CITY OF ALBUQUERQUE

January 27, 2016

Re: Blue Linx Warehouse Adaptive Re-use Project (Resubmittal)
1820 Bellamah Ave., NW
Traffic Circulation Layout
Engineer's/Architect's Stamp dated 1-15-16 (J13-D101)

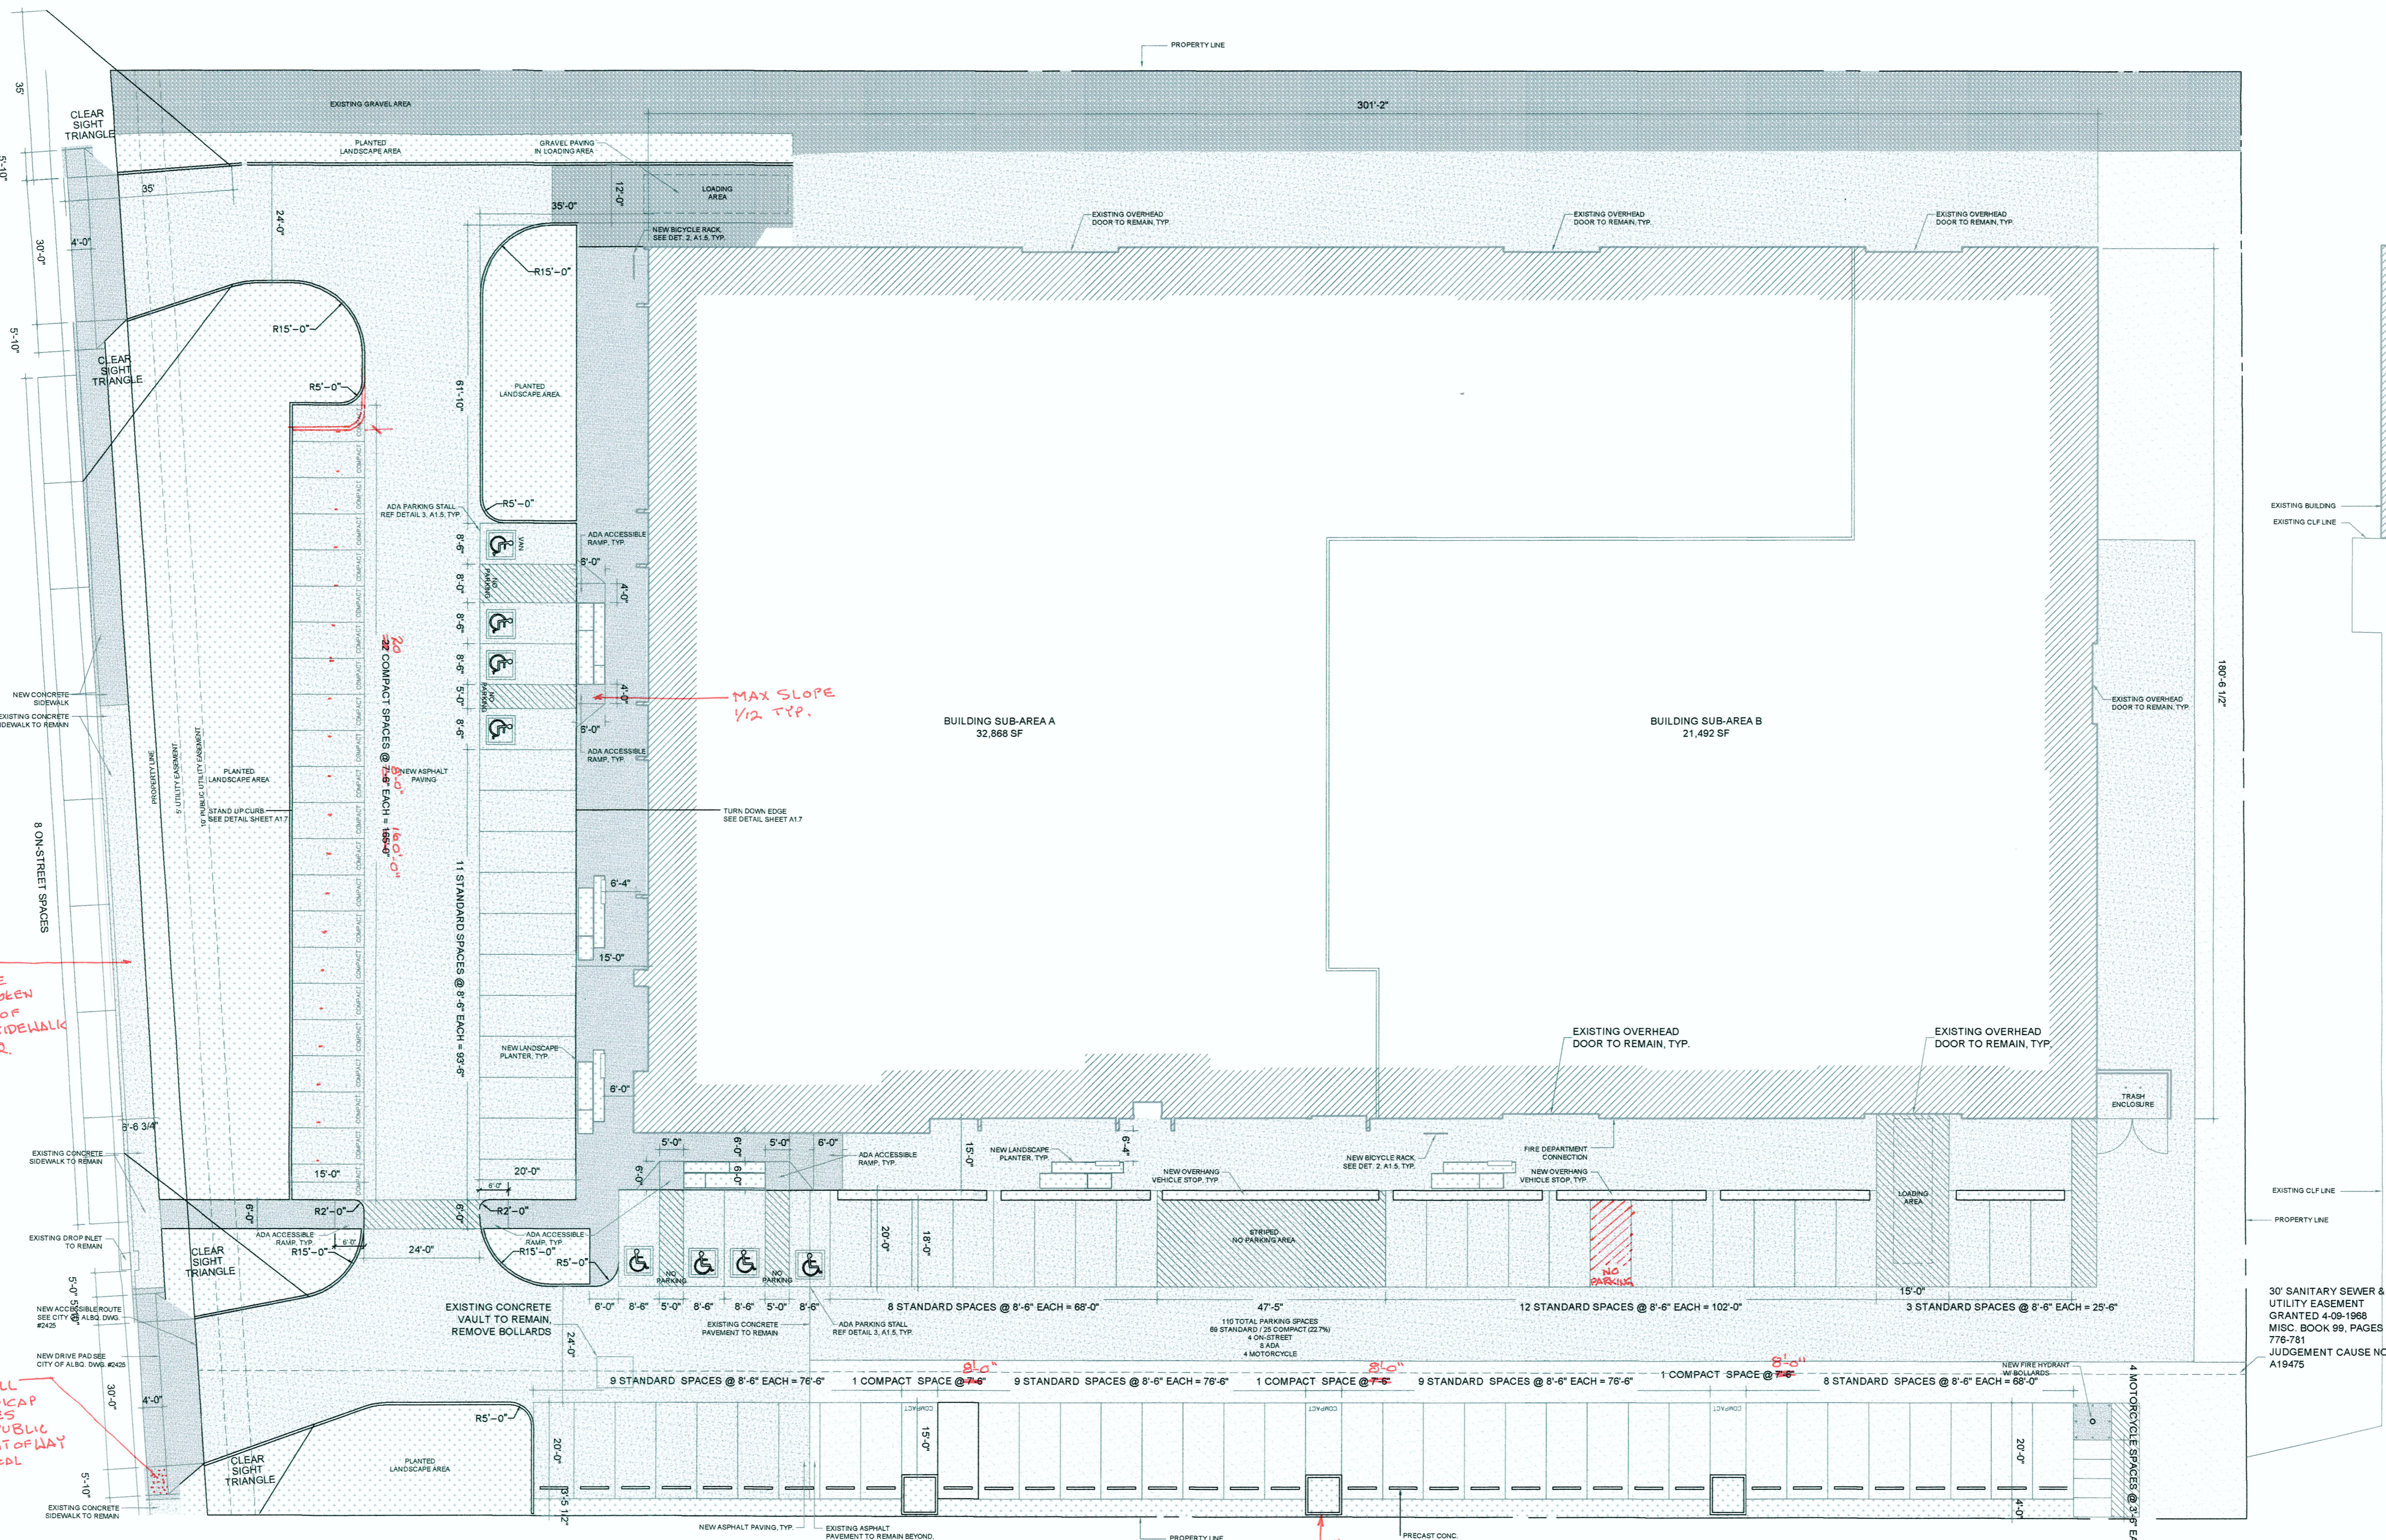
1. Compact parking spaces must be a minimal of 8 ft. in width by 15 ft. in length per COA Compressive Code. In review of the submitted drawing, all compact spaces are dimensioned to be 7.5 ft. by 15ft. Please show detail of reconfigured compact space on new submittal.

2. List the number of parking spaces required by the zoning code as well as the proposed number of parking spaces. Please state the parking calculations with revised count for compact spaces.

3. Identify the right of way width, medians, curb cuts, and street widths on 18th and 19th St.
4. Per Fire Marshall, a fire line access isle will be required in front of the AFD connection point on the west side of the building.

5. Please identify and dimension all existing and proposed sidewalks, pedestrian walkways and entrances to existing building. Note that hatch details make review of dimension difficult, if detail is too dark to read underlying dimensions.

6. Please detail and dimension all existing handicap ramps on public right-of-way and drive pads.
7. Please provide a detail of ADA access ramps to building entrances.

8. Per the DPM, a 6 ft. wide ADA accessible pedestrian pathway is required from the public sidewalk to the building entrances. Please clearly show this pathway and provide details. In review of submittal drawing, new ADA accessible route is noted to be located in the drive pad, which is not in compliance to ADA requirements.

9. Provide a min 6" or max 8" high concrete barrier curb or other acceptable barrier between landscaping and parking areas and/or drive aisles. Please call out this detail.

10. Design delivery vehicle route needs to be shown.
11. Service vehicle and/or refuse vehicle maneuvering must be contained on-site; provide a copy of refuse approval.
12. All broken or cracked sidewalk must be replaced with sidewalk and curb & gutter. A build note must be provided referring to the appropriate City Standard drawing.
13. Please include two copies of the traffic circulation layout at the next submittal.
